memorandum

date May 5, 2021

subject Review of 5637 East Mercer Way (MI Treehouse, LLC) – Reasonable Use Exception and Variance Applications (CAO15-001 and VAR18-002)

**TOPOGRAPHIC PLAN**  
**MERCER ISLAND TREEHOUSE**  
**MI TREEHOUSE LLC**  
 PO BOX 261  
 MEDINA, WA 98040

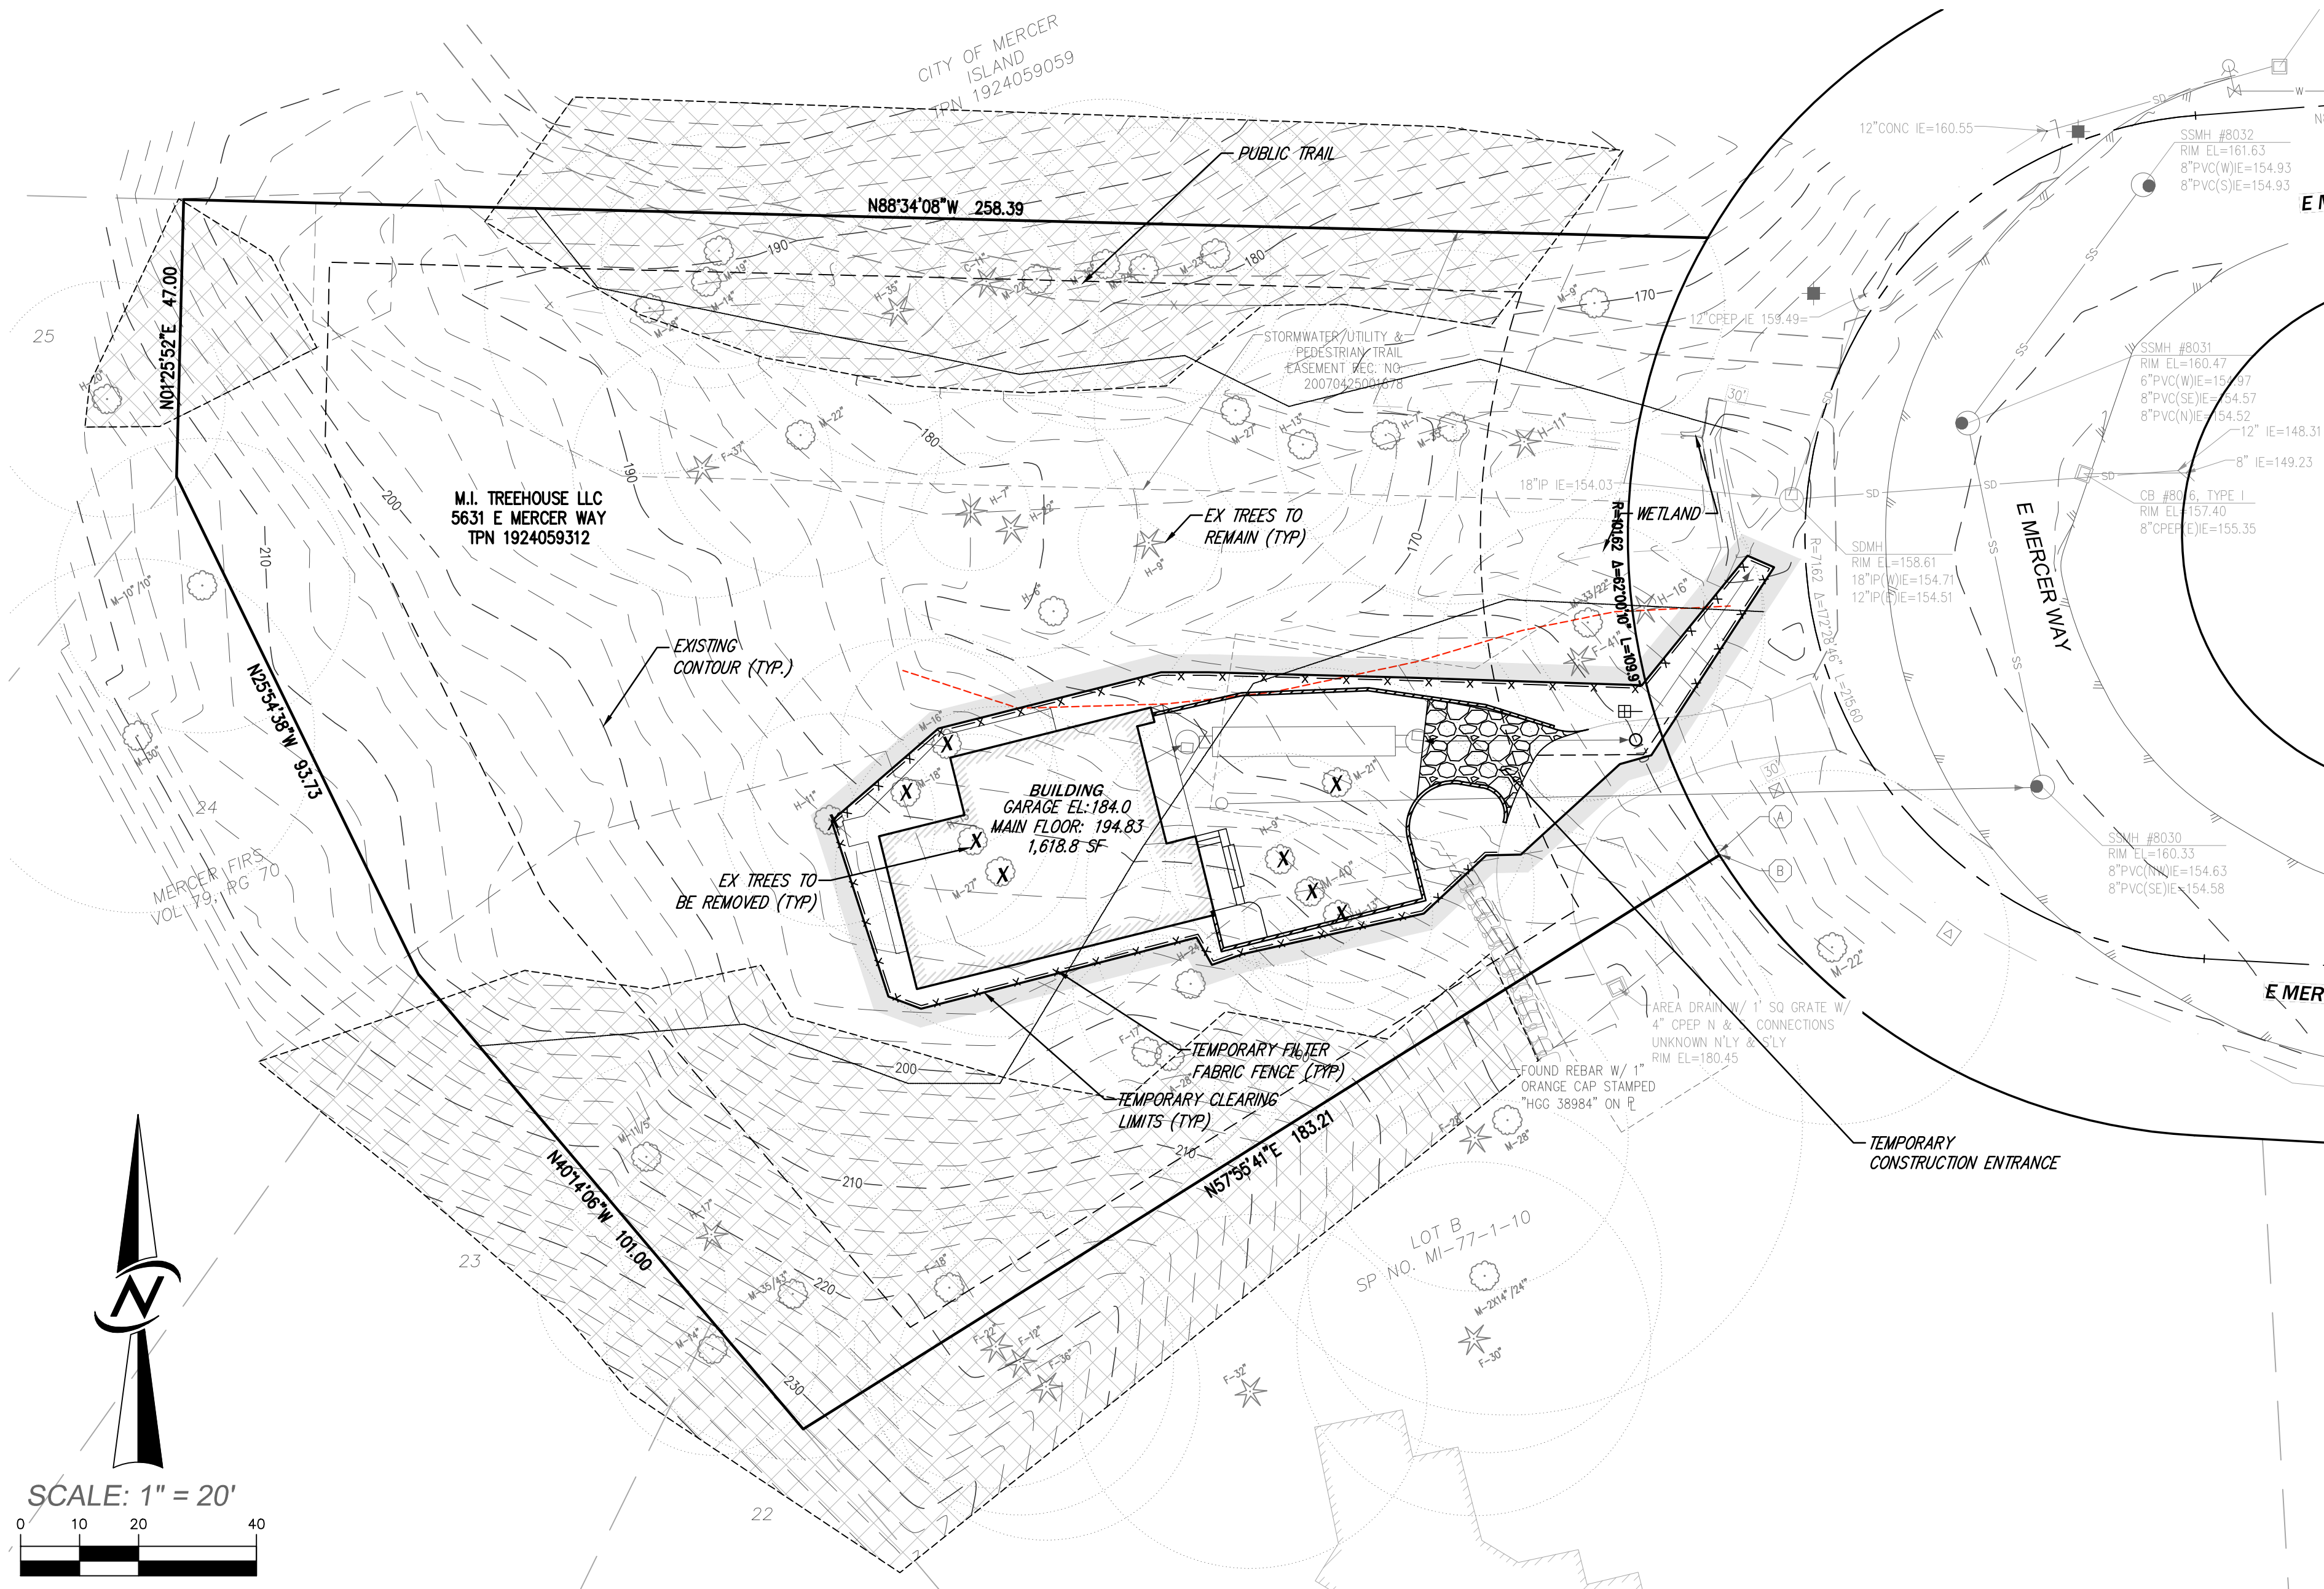
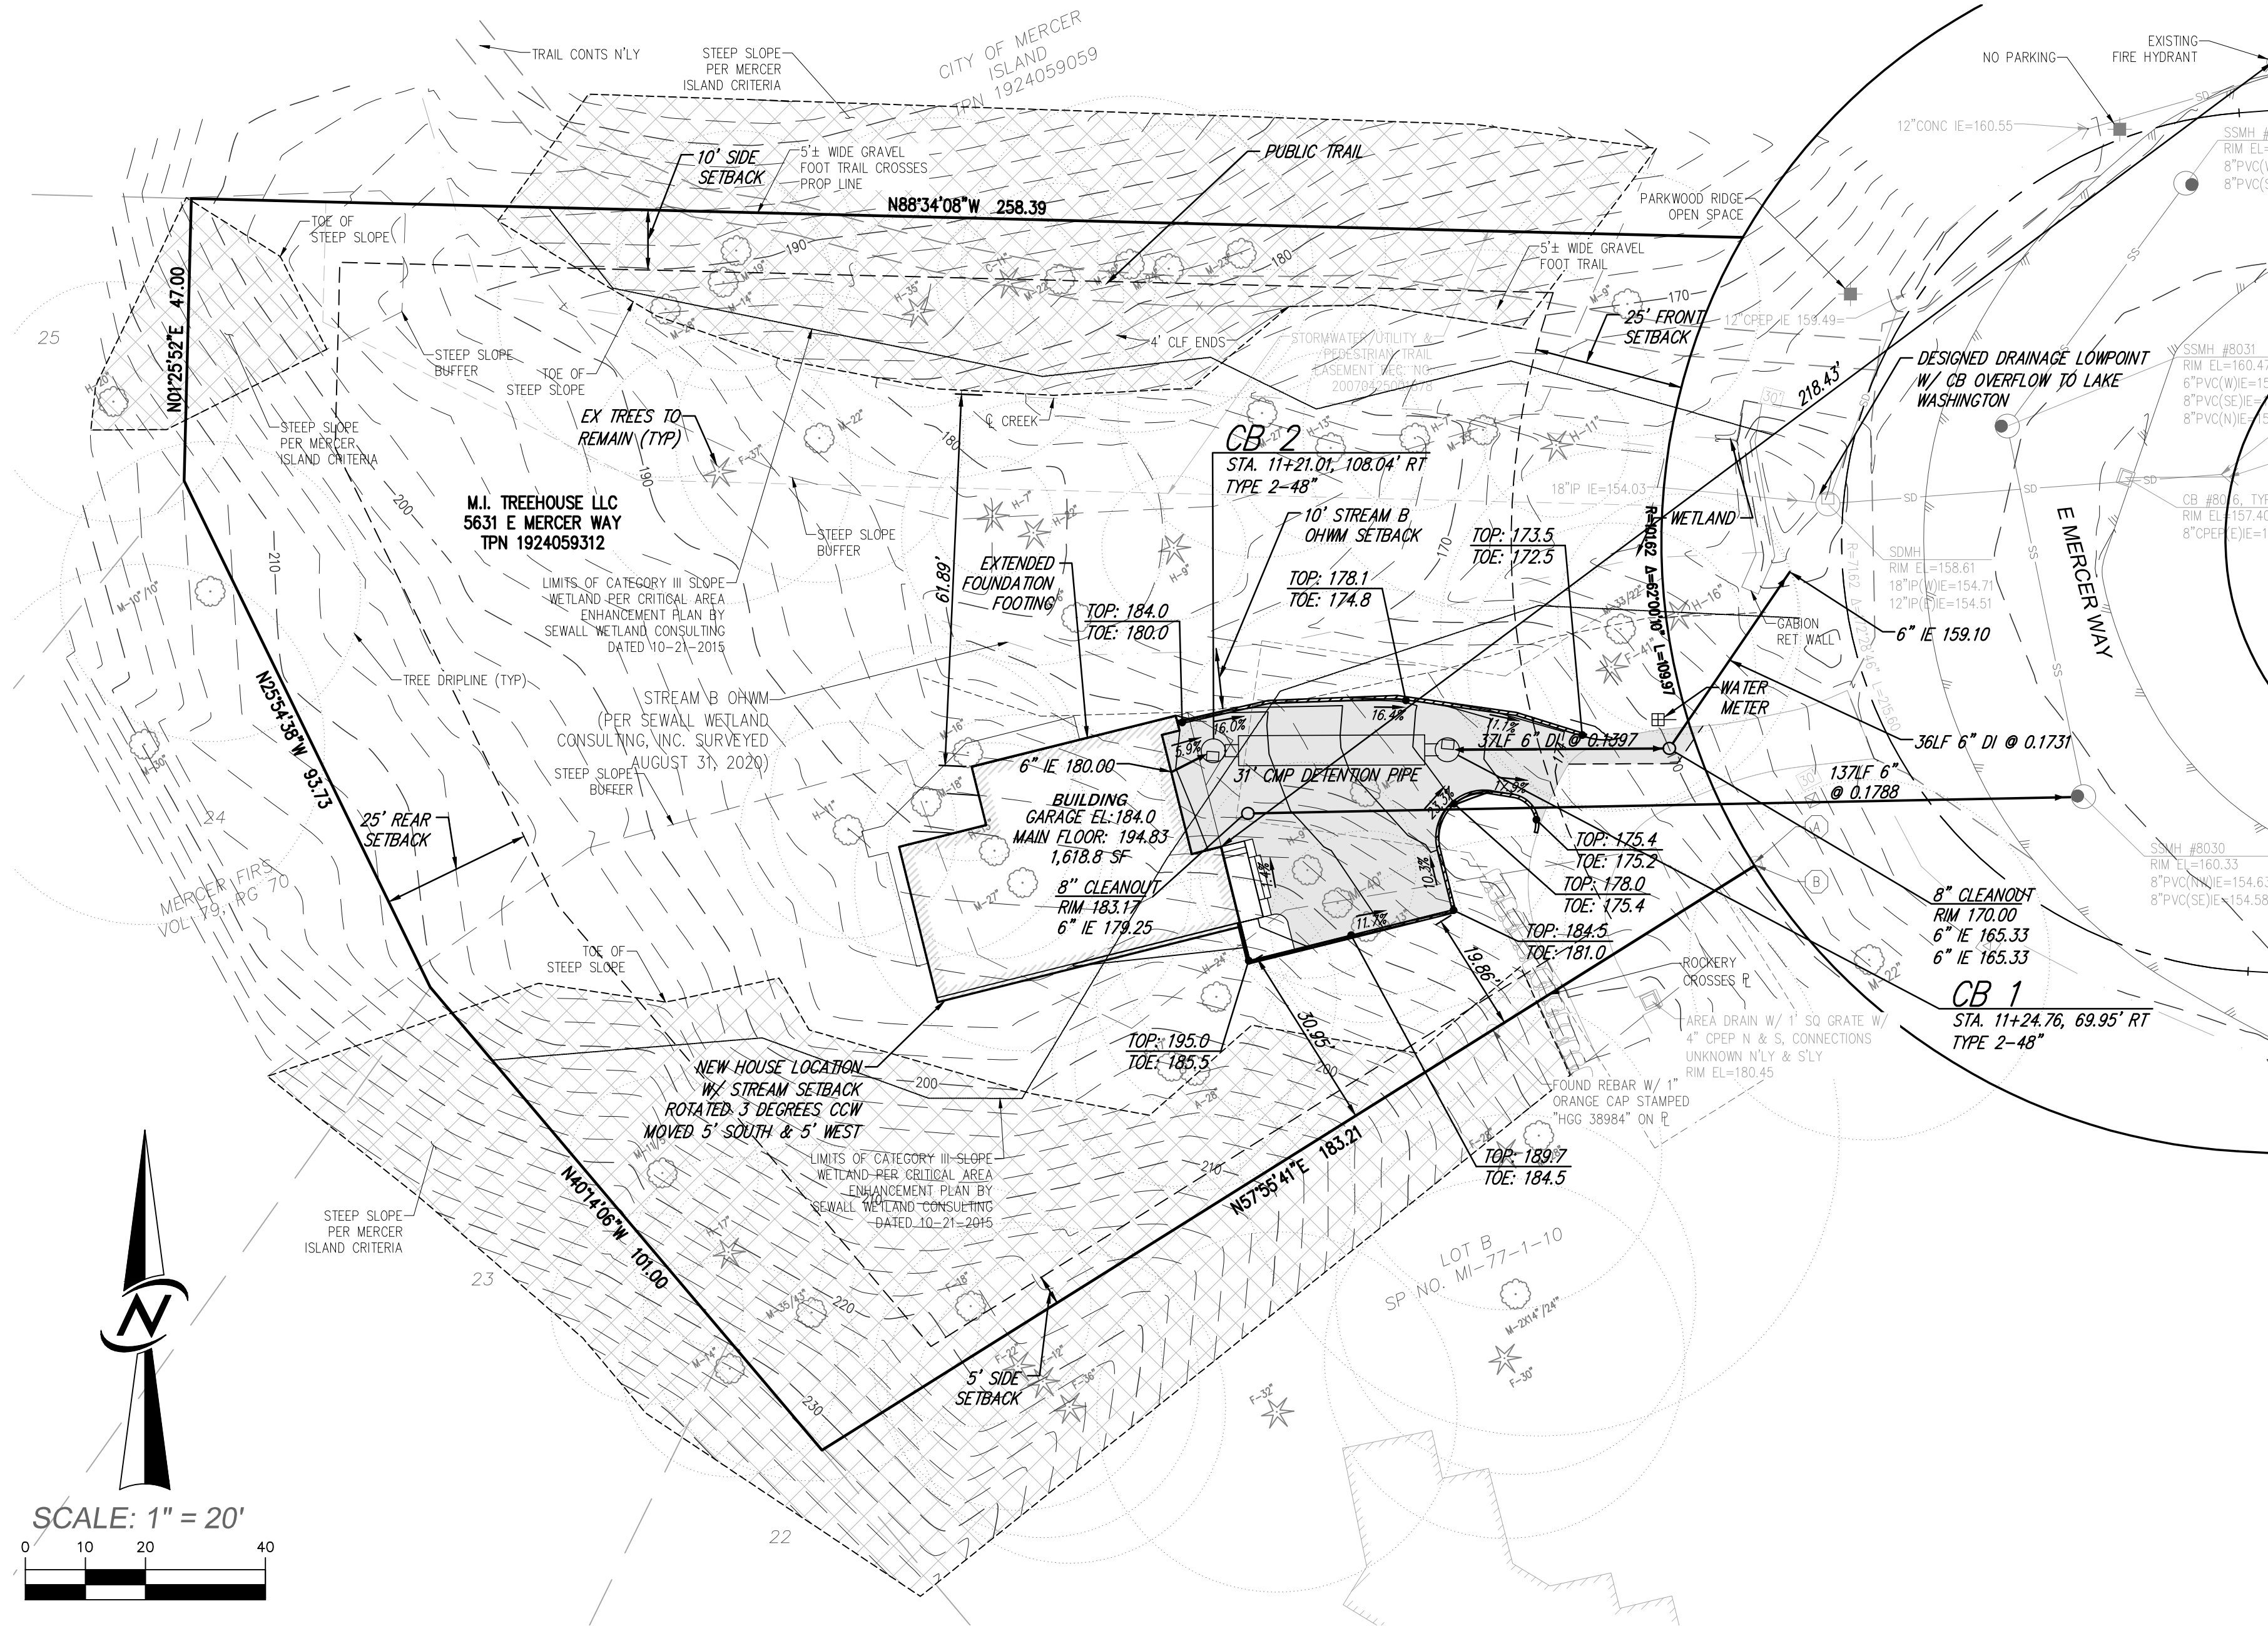
The revised site plan no longer depicts a retaining wall located west and southwest of the proposed residence. ESA previously commented on the wall and associated grading for the building foundation and potential impacts to wetland hydrology. **ESA seeks clarification for the current lack of grading within the slope wetland to accommodate the structure.** If grading is still required, ESA continues to recommend the applicant provide additional details about the onsite drainage system and how it will operate to not artificially drain wetland areas. Alternatively, the applicant can propose an offset from the drainage system that would account for lost wetland hydrology and mitigate impacts through additional credit purchase.
